Reference: 21.185r02v02

9 May 2022

Re: St Aloysius – Rozelle Campus
Response to Request for Information

Swept Path Analysis

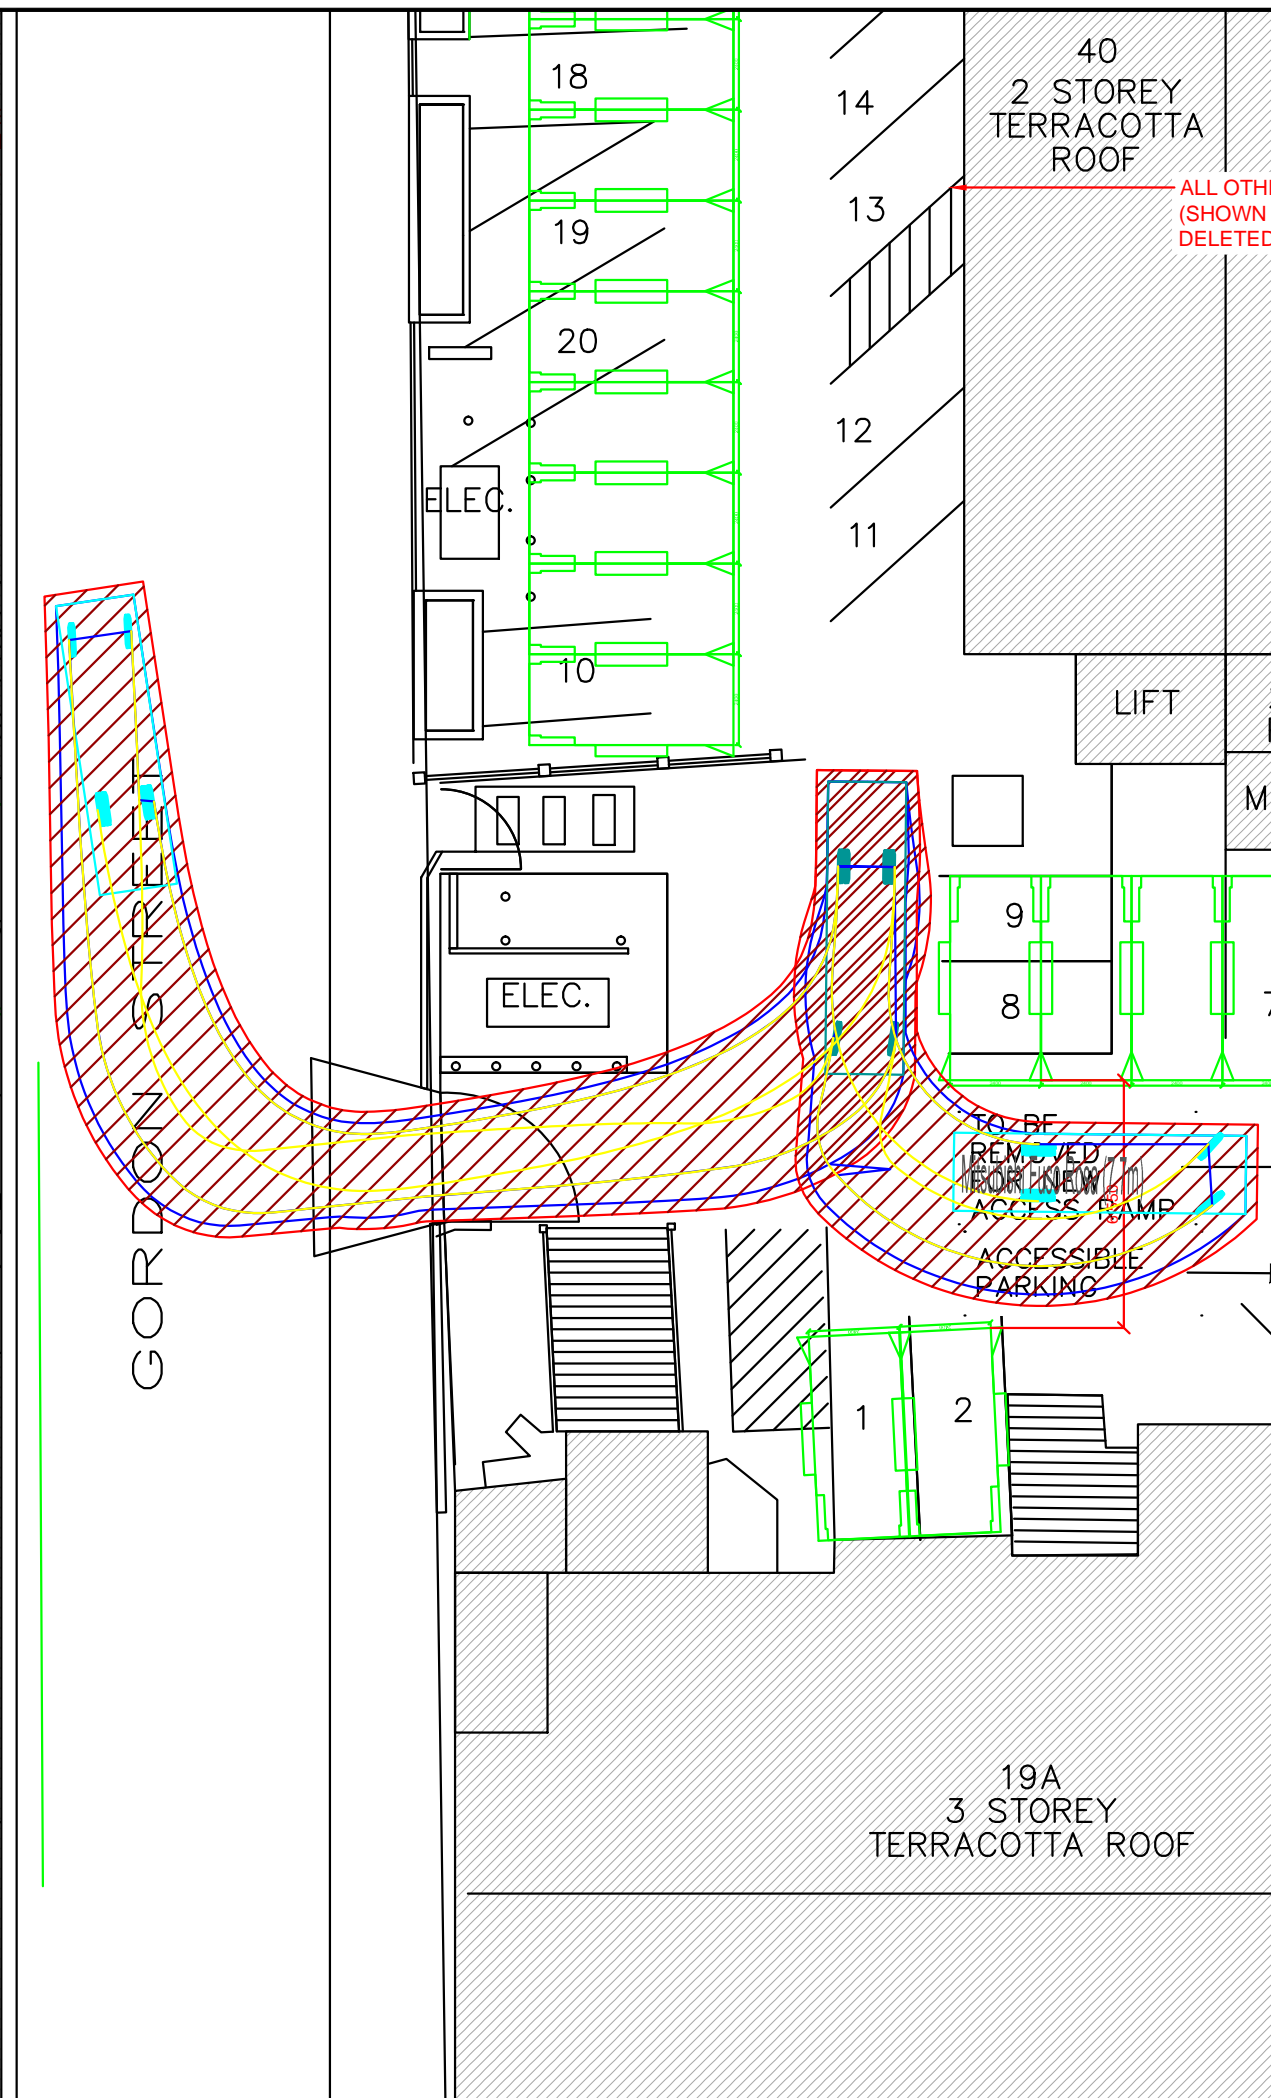
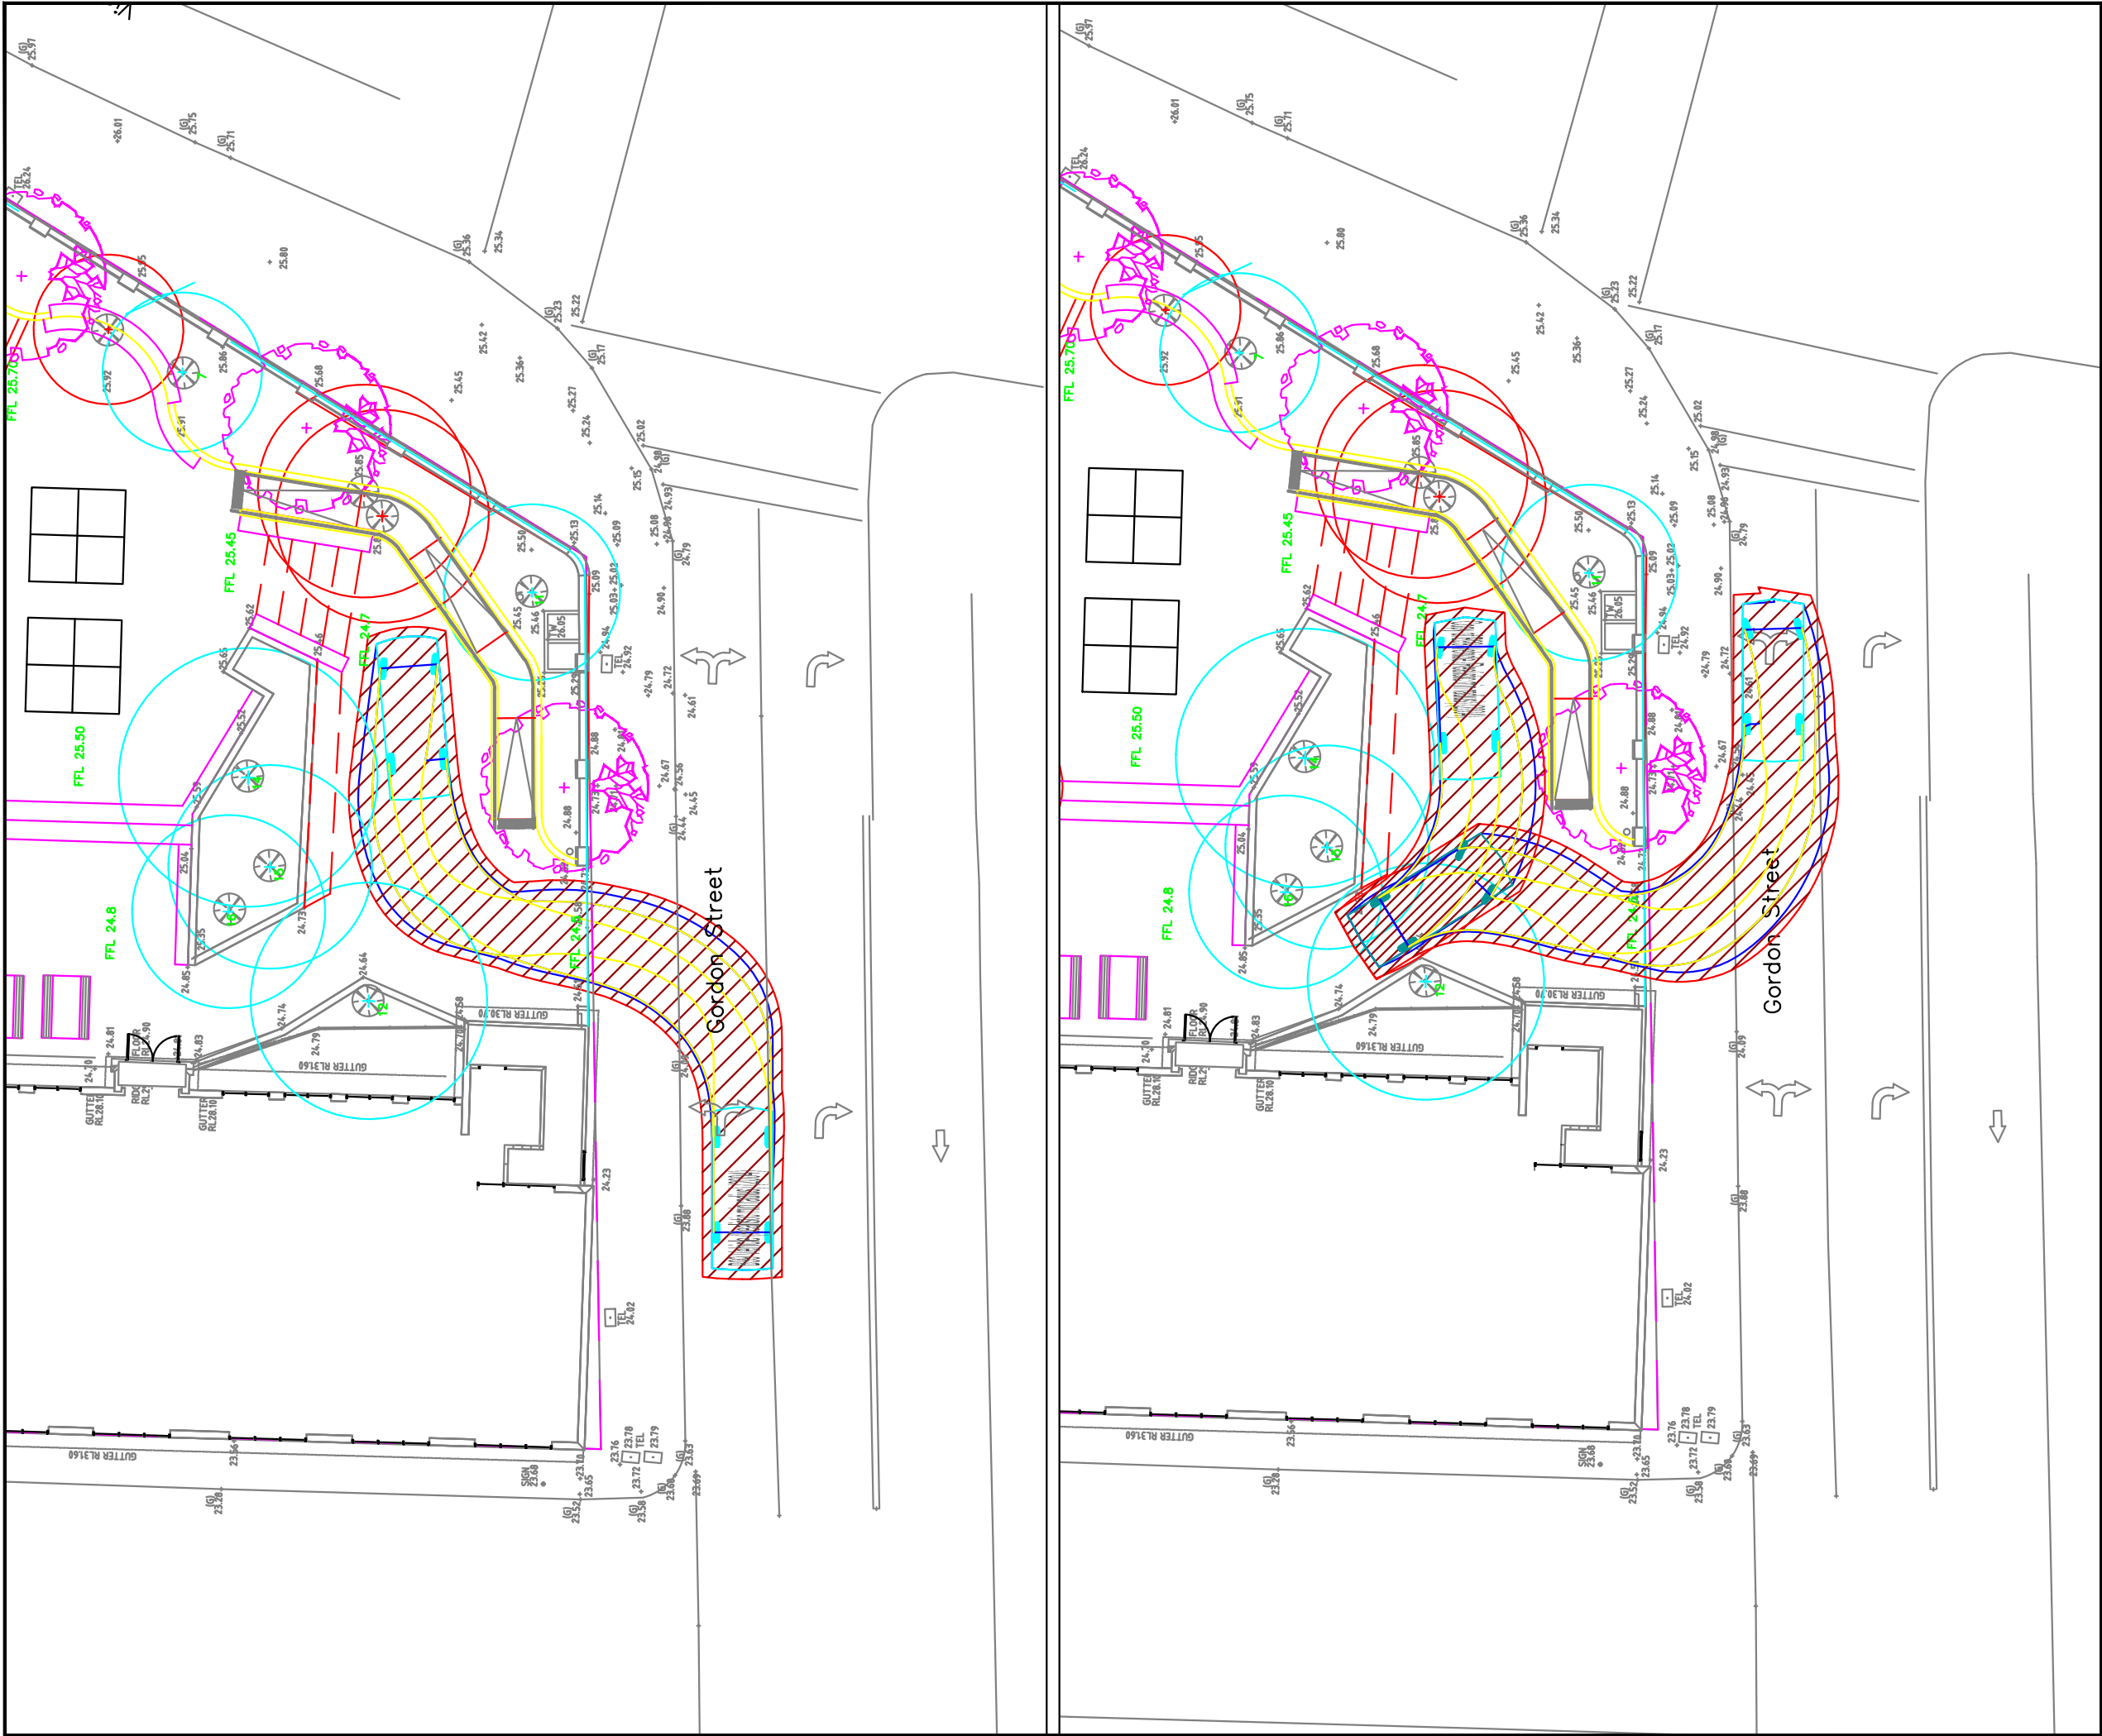
- *"TfNSW notes that the submitted swept paths for vehicles entering the two locations on Gordon Street are not acceptable in their current form (appendix E and F in the Transport Impact Assessment)."*

- *"TAIA proposes that the shuttle service between the Kirribilli and Rozelle campuses will drop off and pick up the students within the car park at 2A/B Gordon Street. The updated swept paths for vehicles entering and exiting 2A/B Gordon Street show that the vehicle body envelope will collide with the bollards around the existing pad mount (See the screenshot below), which is unacceptable. Additionally, it is better to consider a 600mm Clearance Envelope for the shuttles. Please provide additional information to address this issue.."*

The updated swept paths are included in the updated TAIA report.

The swept paths have been revised to be clear of the bollard area and this is provided within Appendix H of the revised TAIA. The swept path analysis shows satisfactory movements with no encroachment of bollards into the manoeuvring area for the vehicle.
